About the application

Application number: 2021/92983	
What is the application for?:	Erection of single storey rear extension and external alterations
Address of the site or building:	Among Balay, 24, Gynn Lane, Honley, Holmfirth, HD9 6LF
Postcode:	HD9 6LF

DRAWING TITLE: GA as Proposed

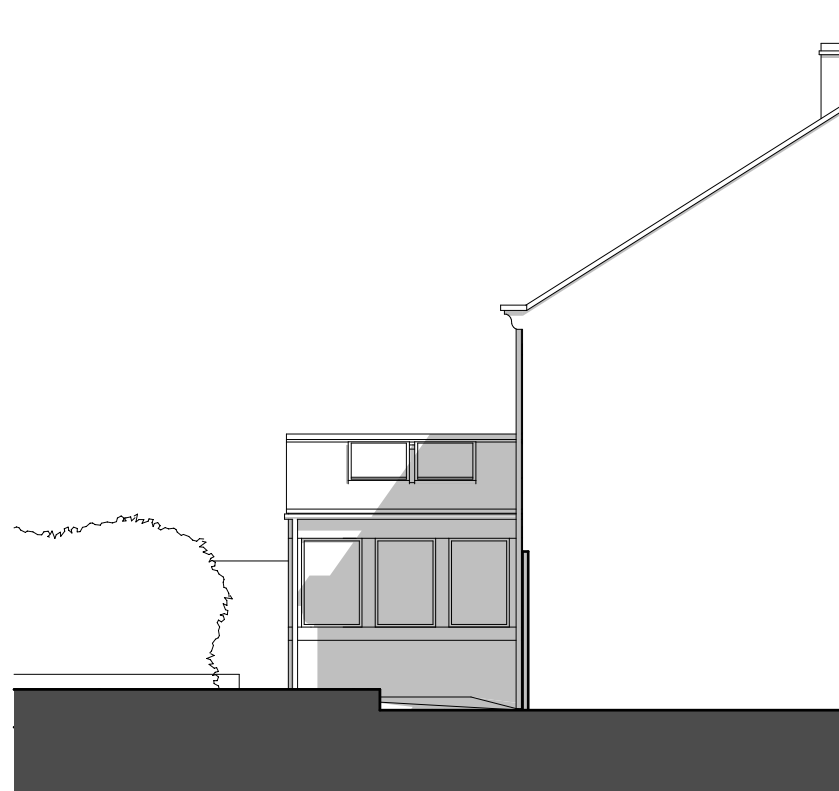
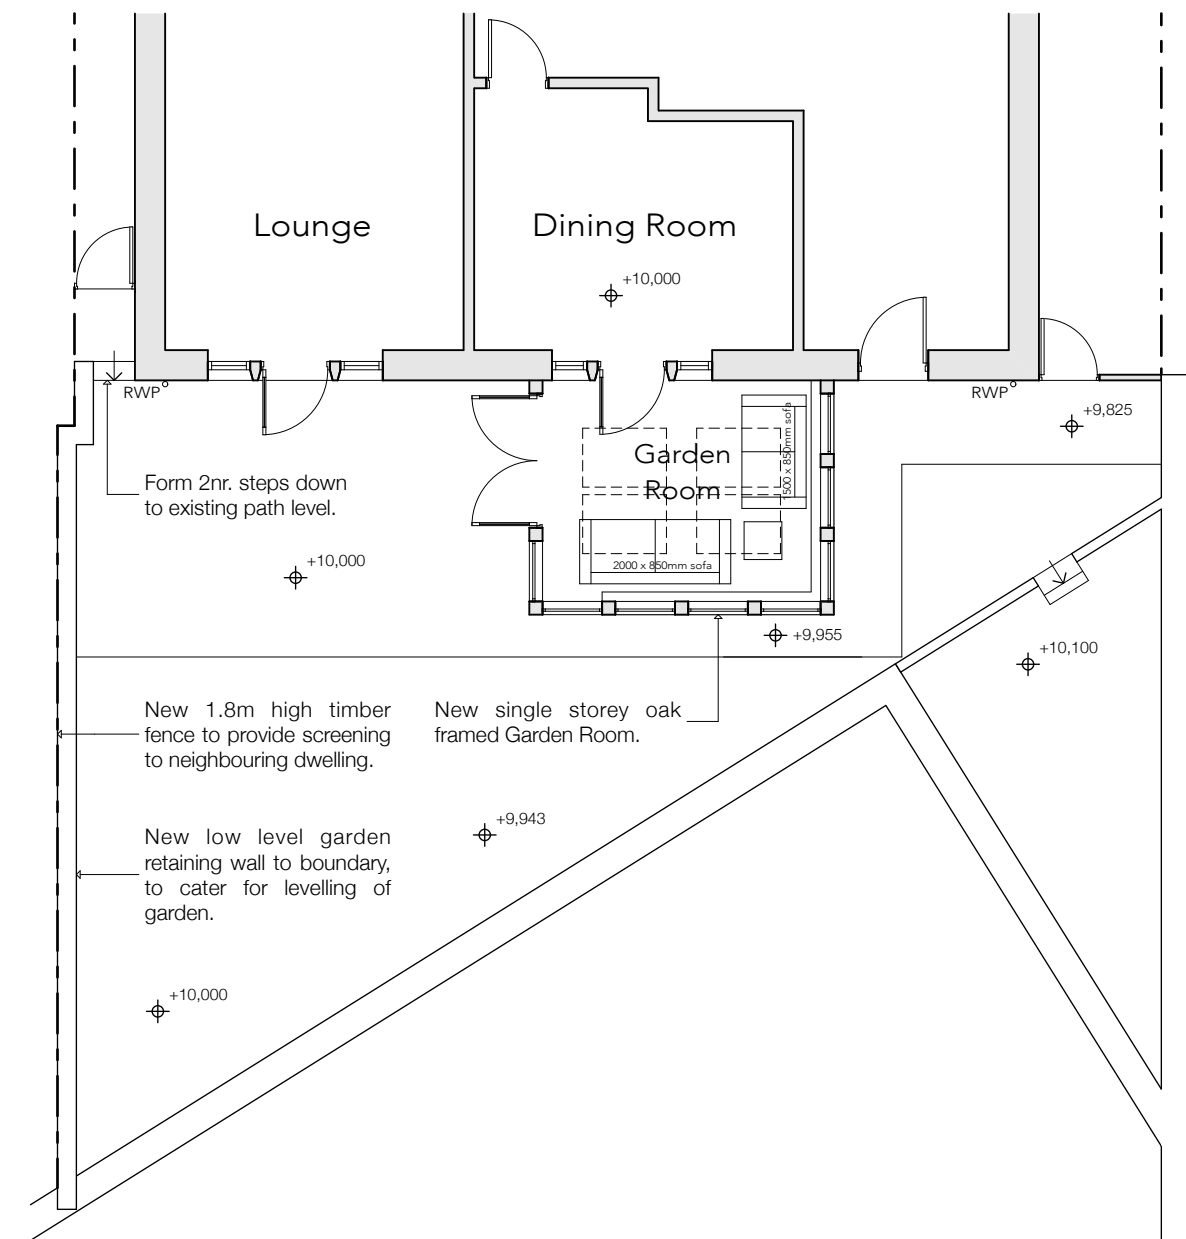
1. In the application number 6 specifies 'there will be no trees or hedges removed or pruned'. This is true of the extension but not for the fencing as there is significant hedging along the boundary and some of it will have to be pruned/removed for the retaining wall and fence. A lot of this belongs to us.

2. It appears that the level the extension will be on is to be raised higher than the existing level with doors and windows facing onto our property. As they are already higher than us, we are concerned at the intrusion this might have.

3. There is to be 'a new low level garden retaining wall to boundary to cater for levelling of garden' with a 'new 1.8 metre screening fence to provide screening to neighbouring dwelling'. Whilst we feel the fence is a good idea, we have concerns regarding the construction and height given that this will be on top of a retaining wall.

Firstly, the boundary line drawn on the plan submitted differs to the one I have from our initial purchase in 2002, it appears they are showing it in our land.

Secondly, we are not accepting of a wall being built on the boundary as this will mean there is significant disruption to our hedgerow and the existing fence (installed by the builder at our request prior to completion of our purchase and prior to the neighbouring property being built) would have to be removed. This is not an option as we have dogs and the garden would no longer be secure if the fence is removed.

Thirdly, Is the intention to run the fence between the two houses and if so, I do not agree to this being on the boundary wall nor to the height being at 1.8m. The boundary wall is already 0.7 metres high and adding a further 1.8 metres onto this would affect light into our property and creation of narrow passage which could be an issue for any remedial maintenance of our property.

We ask that any work for fencing and retaining wall is done within their own land, be aesthetically pleasing and any damage to our property and planting be repaired or replaced by them.

DRAWING TITLE: Culvert Plan

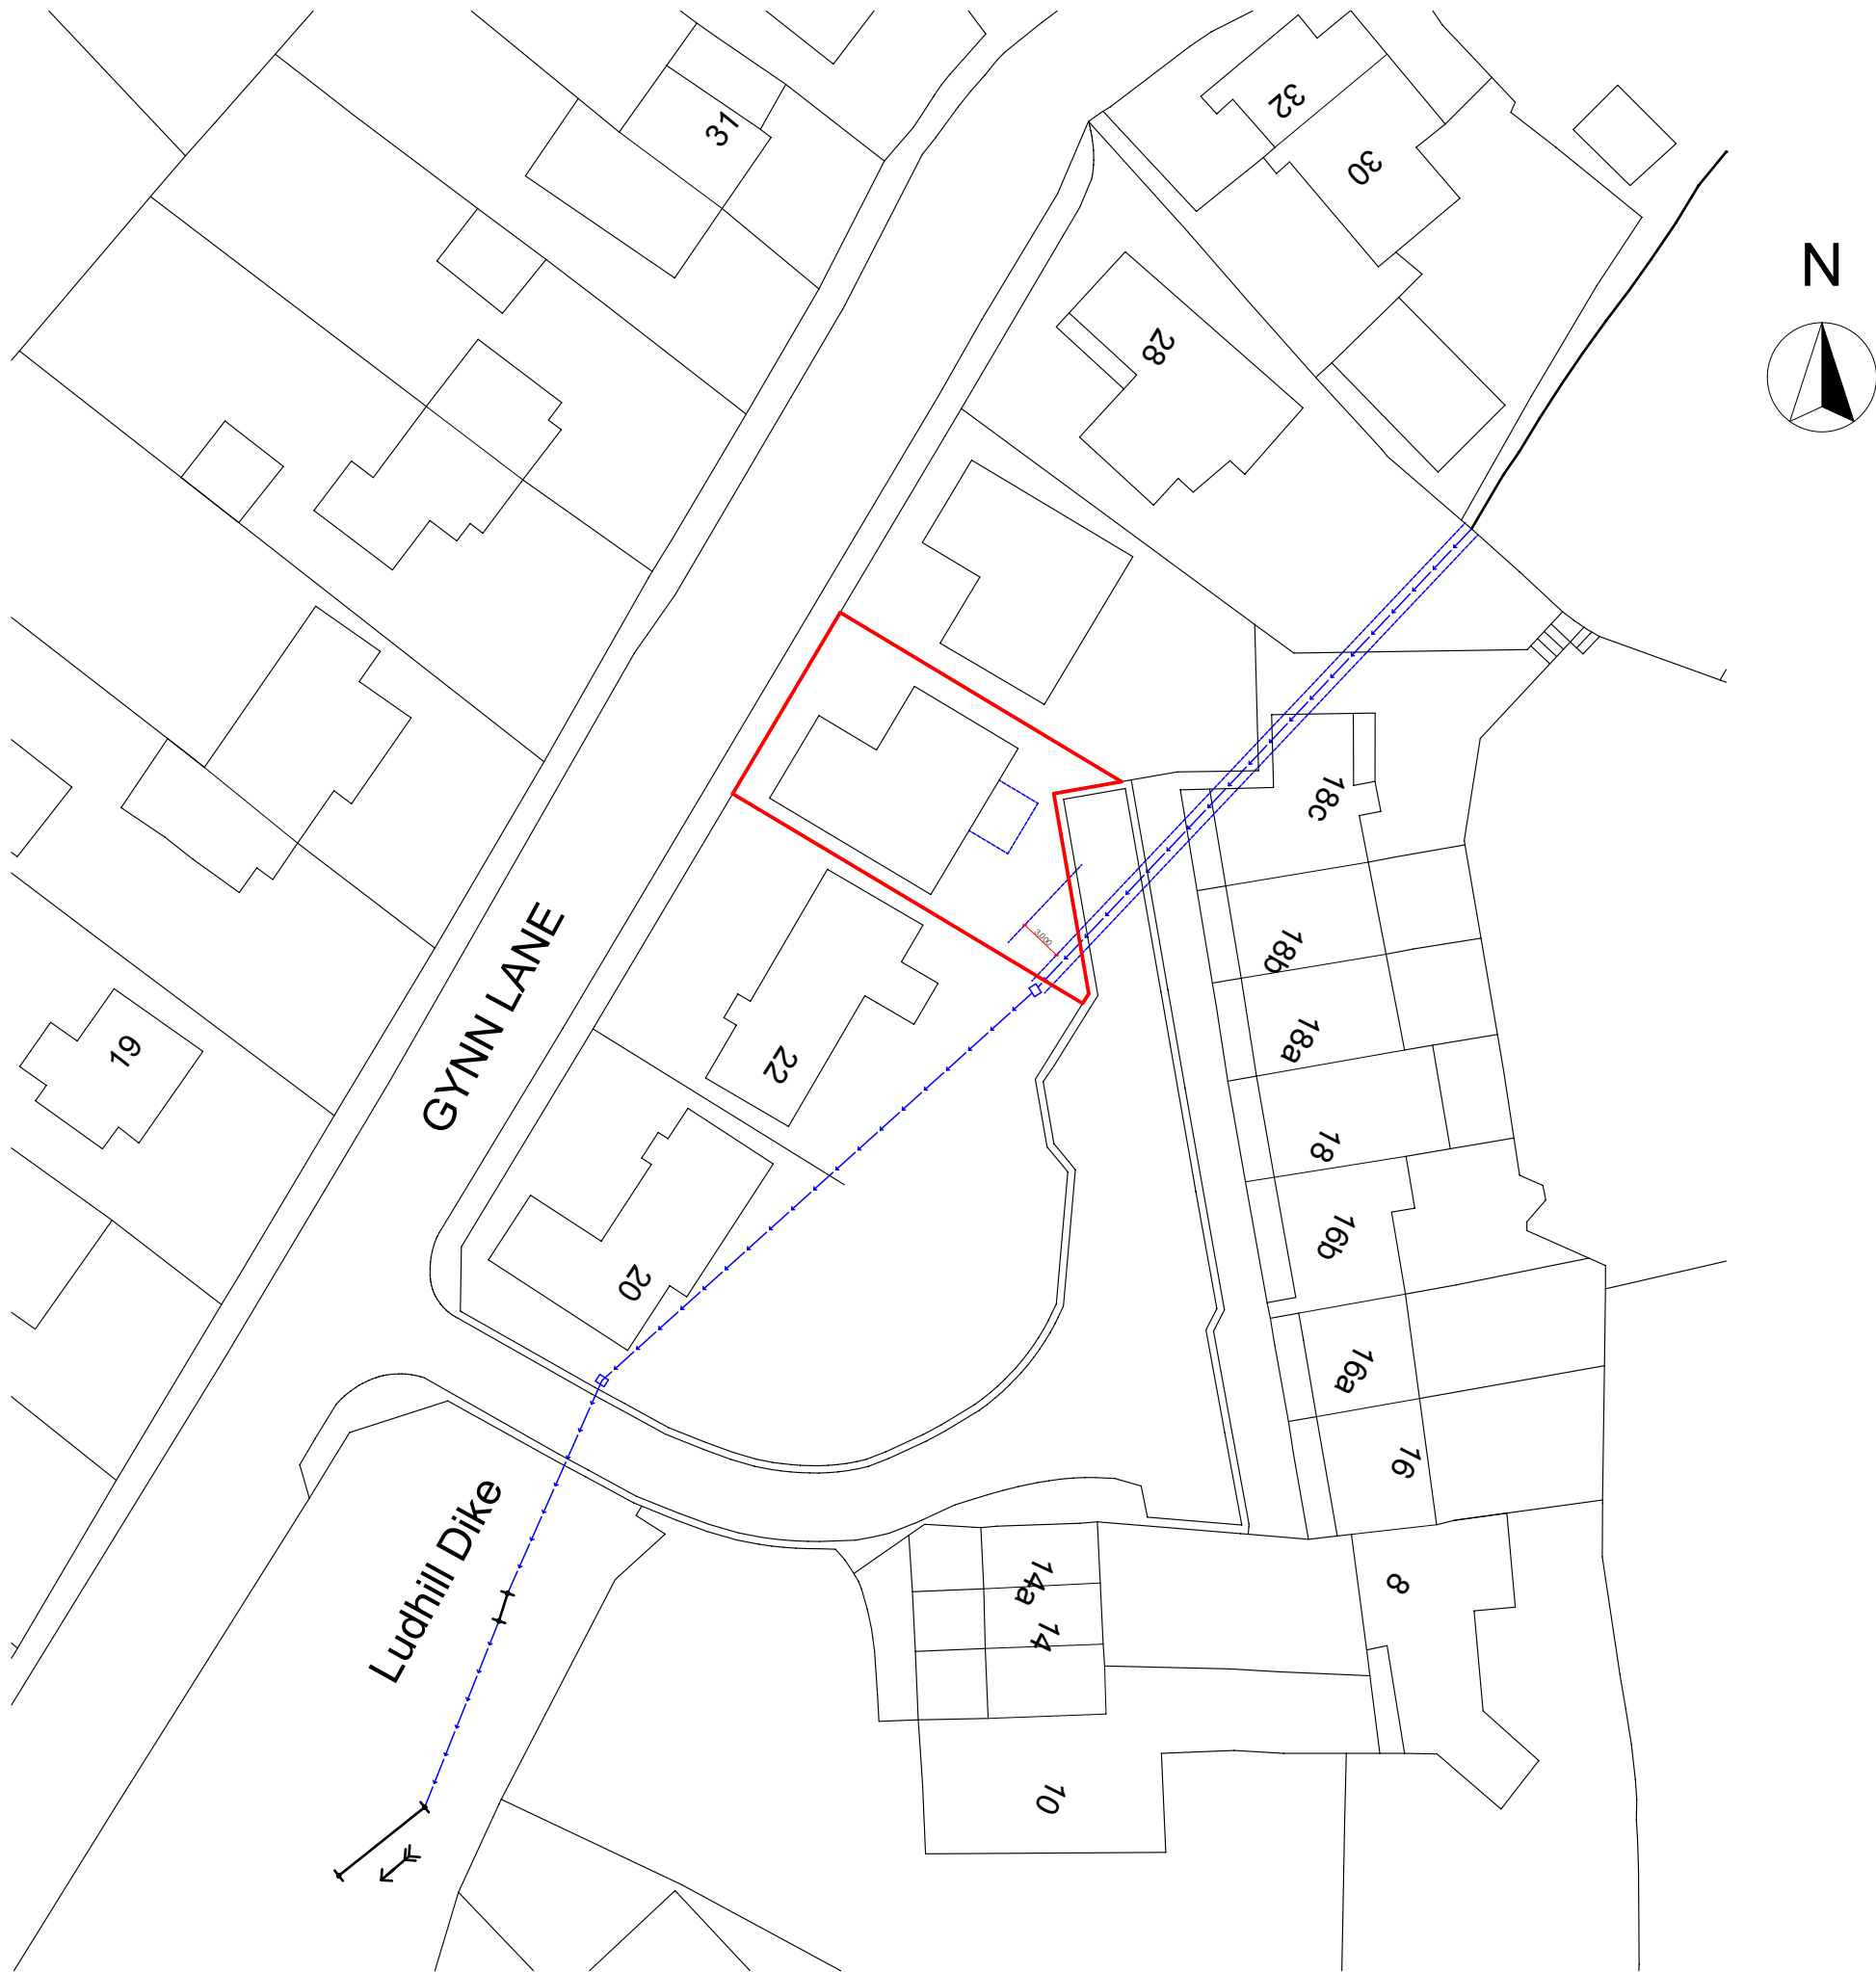
Finally, there is a culvert which runs through the top of the garden so any digging in this area needs to be mindful of this.
